Development Facilitation Team (DFT) – Review Comments

Project No: PR-2021-005717 Date: 08/23/2023 Agenda Item: #1 Zone Atlas Page: C-9

Legal Description: [Tract 2 Unit 2, The Trails]

SUBJECT: Preliminary/Final Plat, Vacation of Easements, Waivers

1 TYPICAL 32' STREET SECTION STA 20+35.08 TO 23+43.61 SIDREAU LOOP AND ATHERSTONE LANE
NOT TO SCALE

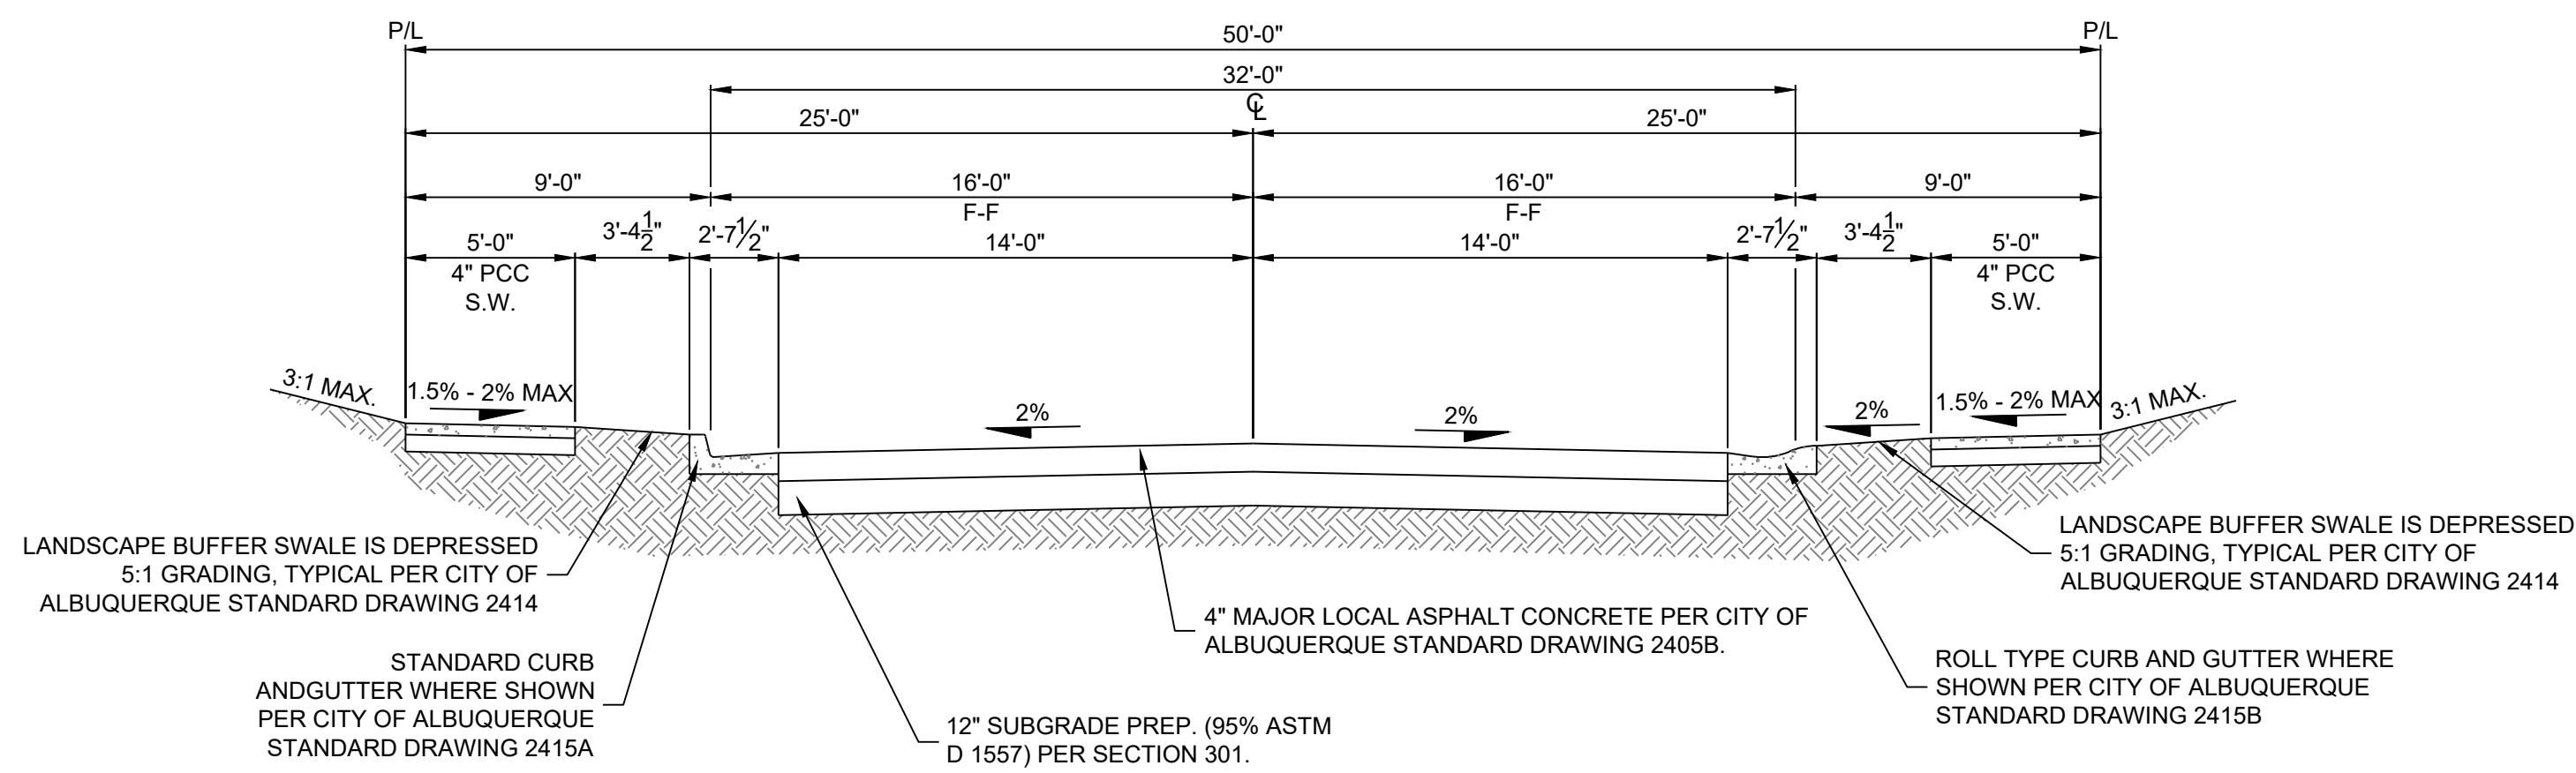
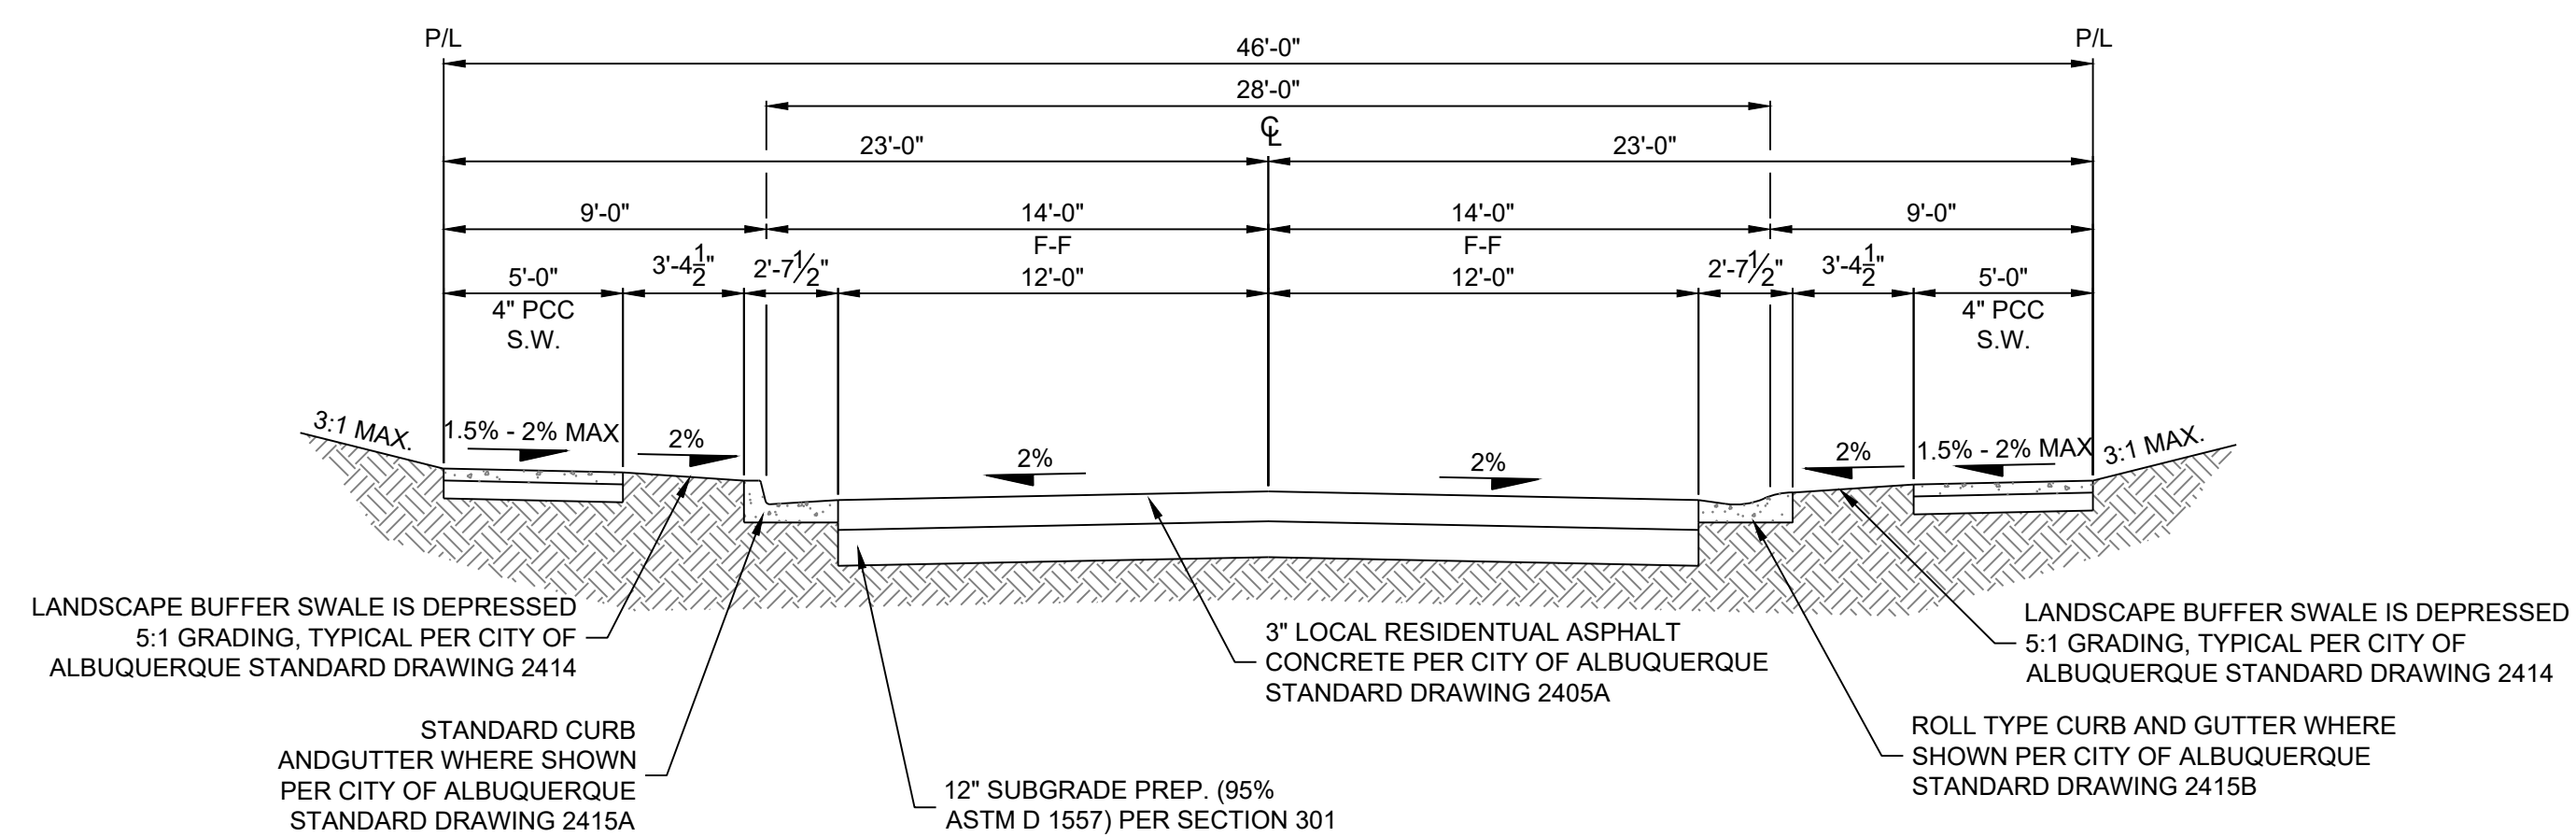
1. Landscape buffers along internal streets are narrower than the 4' minimum called for in the DPM. Transportation defers to Parks and Rec and Planning as to whether this is acceptable.
2. All other comments have been addressed. No objection.
